Application no: H19/0424/98

Location: Pt OS 8525, Broadgate Road
Sutton St Edmunds
Spalding
Lincs

Amendment: As built - plans for farm buildings
Dwg.Nos. SM.02B; WD1890/1A & /1B

TOWN AND COUNTRY PLANNING ACT 1990
NOTICE OF ACCEPTANCE OF AMENDMENT

JOB No. *B 237*
DRAWING No. *1 A*

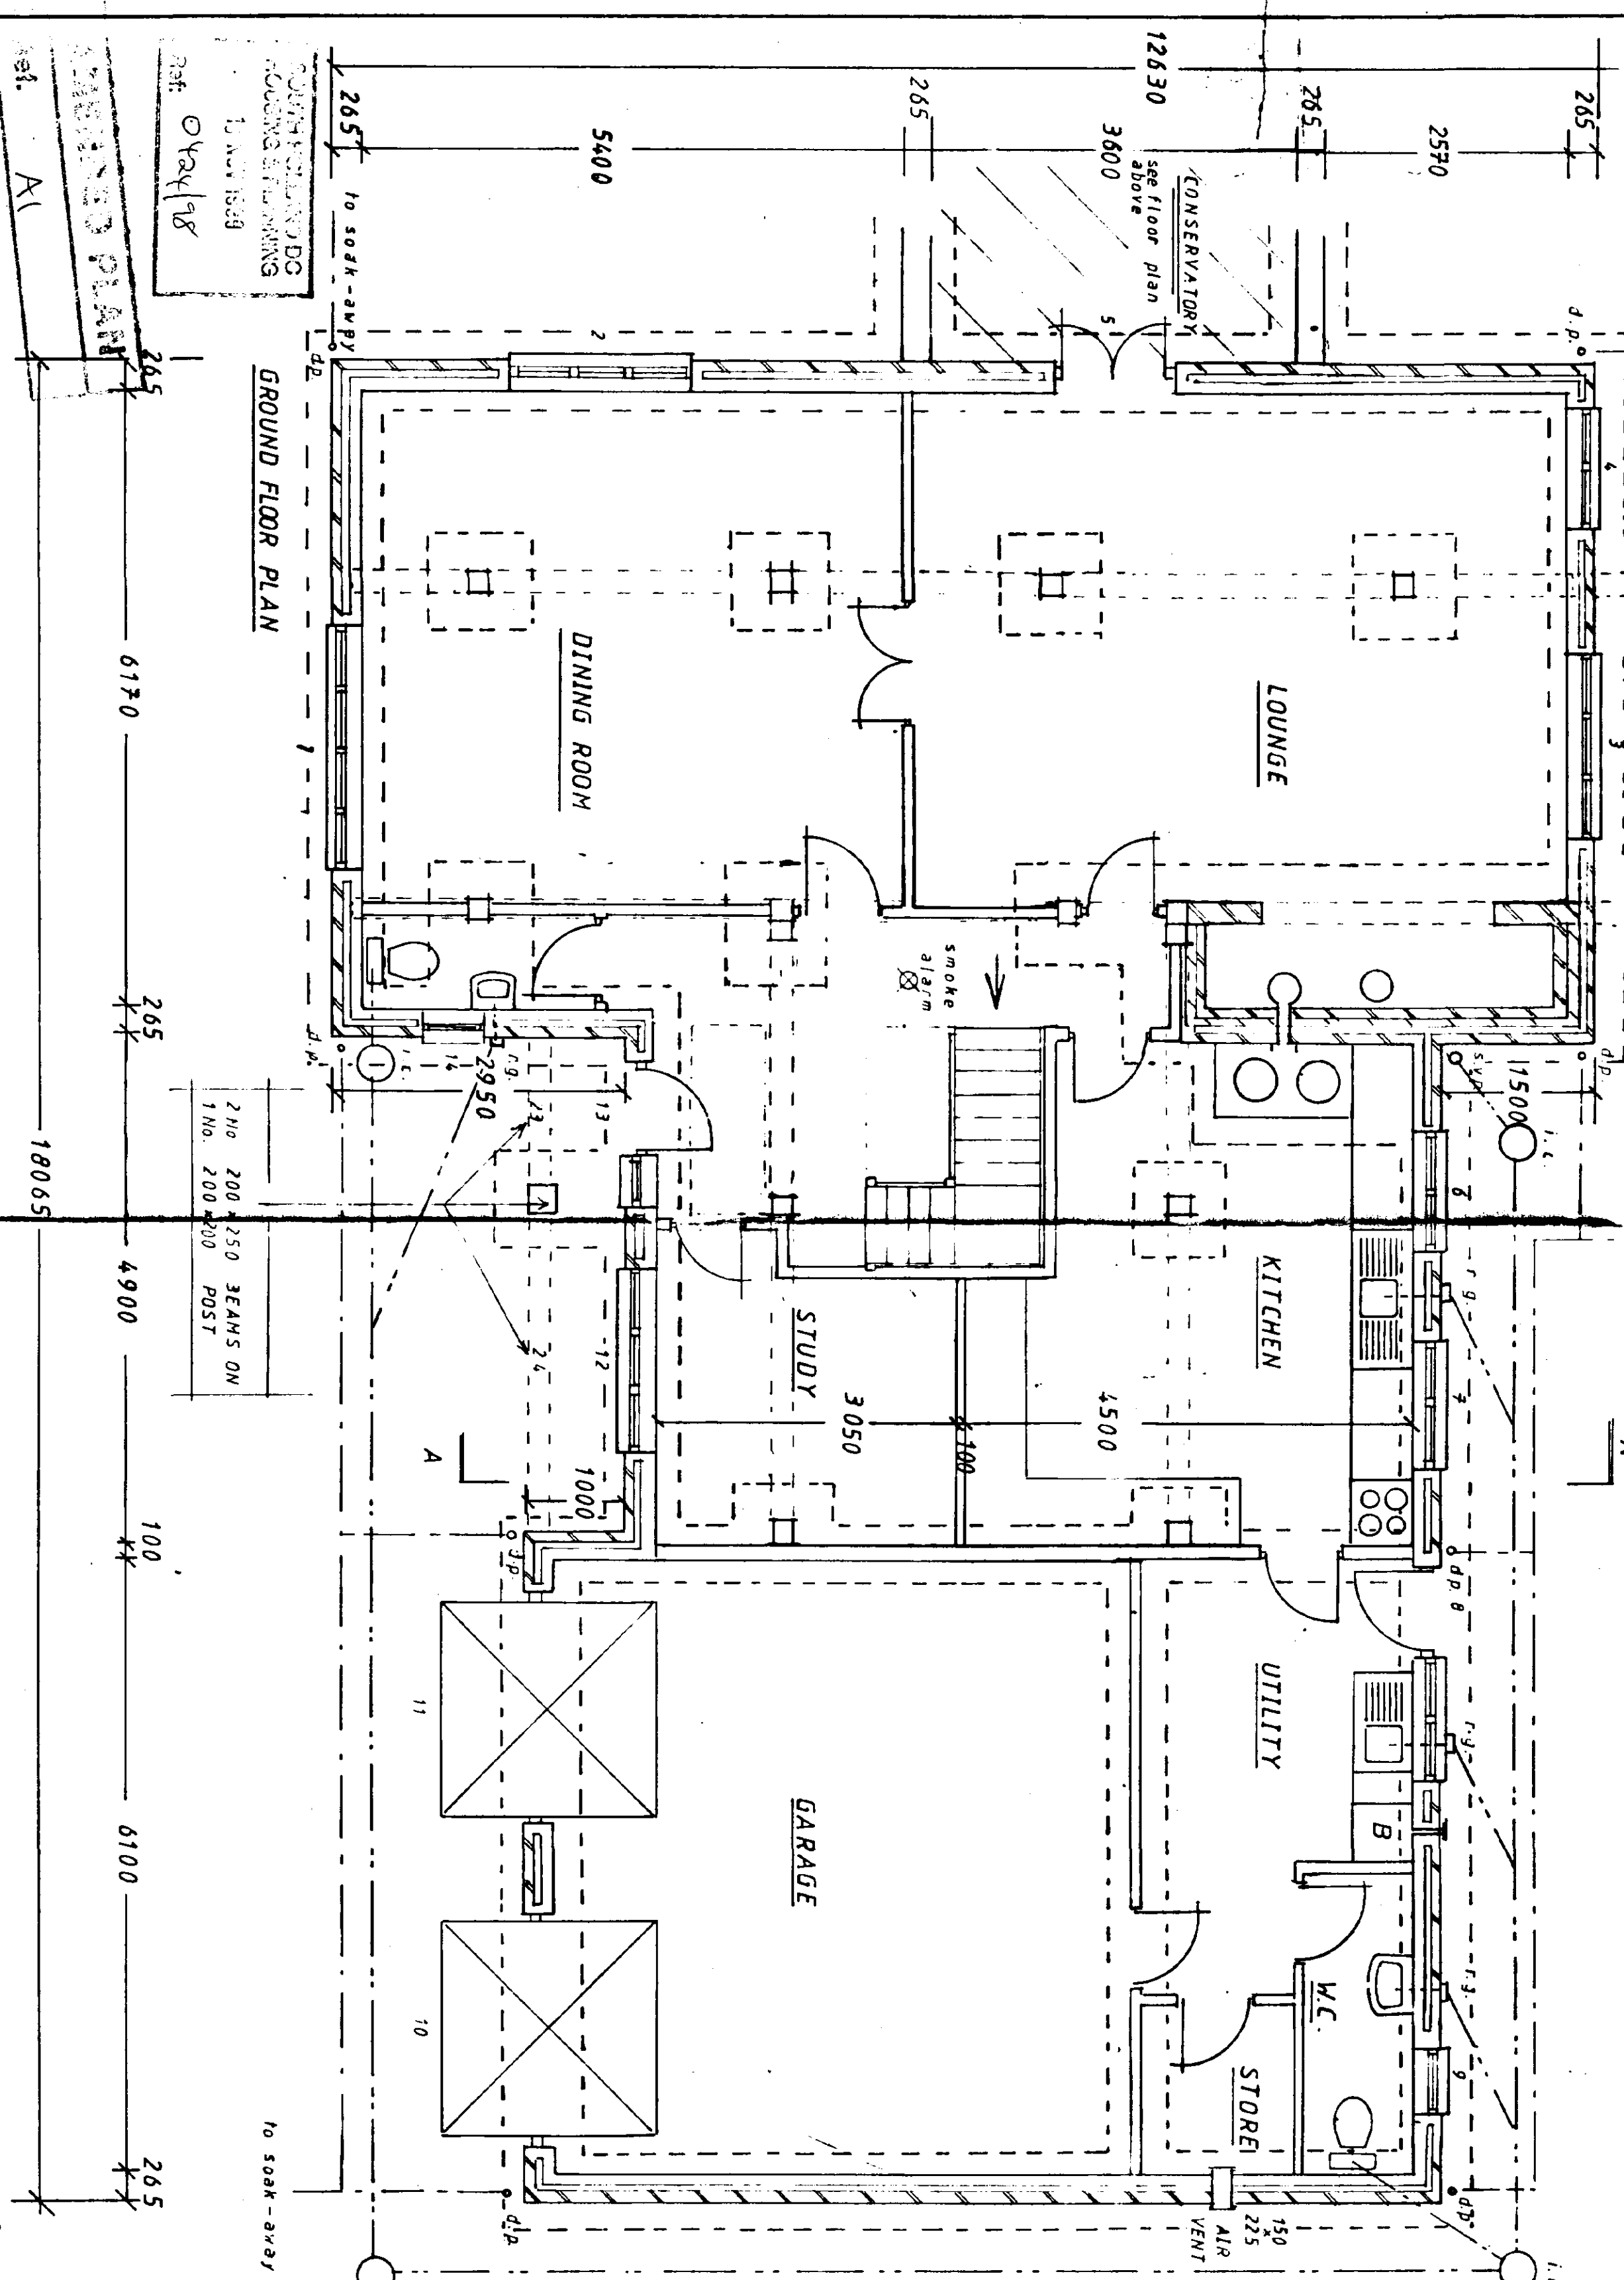
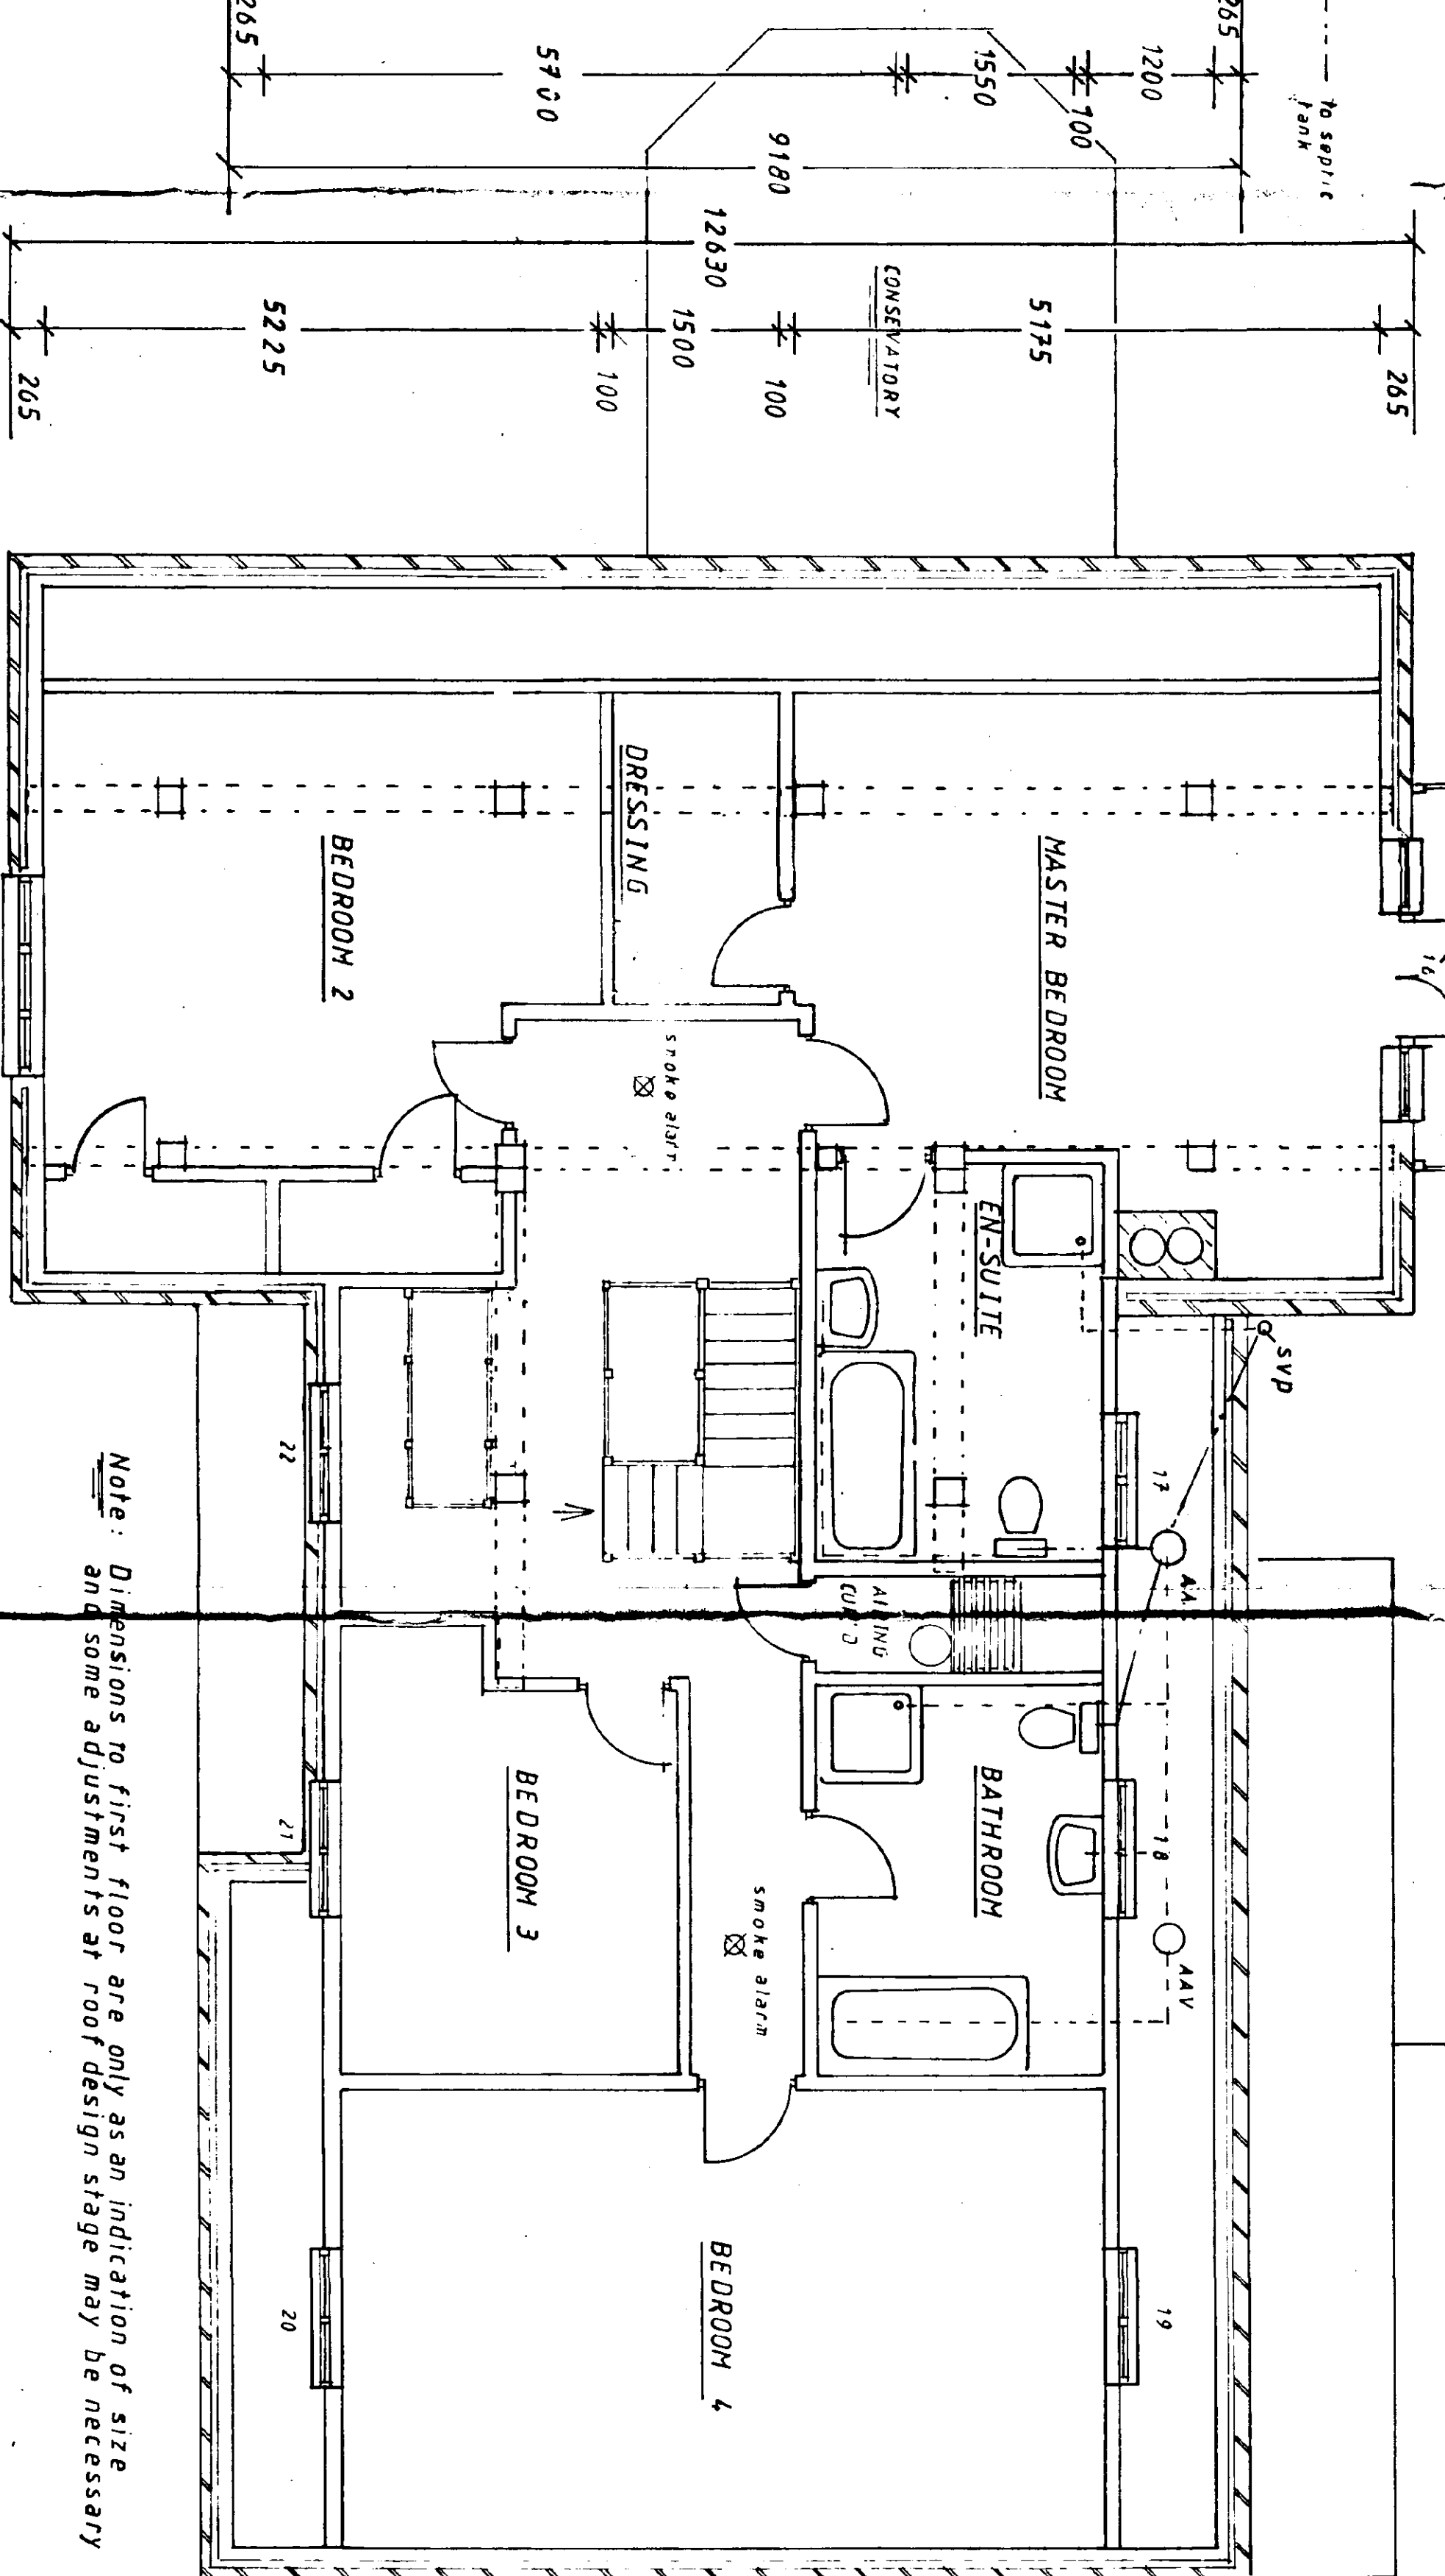
Amendment: Re-position conservatory, remove dormer window to sth
elevation, change window to french door etc

RE-POSITION CONSERVATORY FROM
WEST ELEVATION TO SOUTH ELEVATION.

REMOVE DORMER WINDOW TO SOUTH
ELEVATION.

CHANGE WINDOW TO FRENCH DOORS / WINDOW
TO BEDROOM, INCLUDING BALCONY.
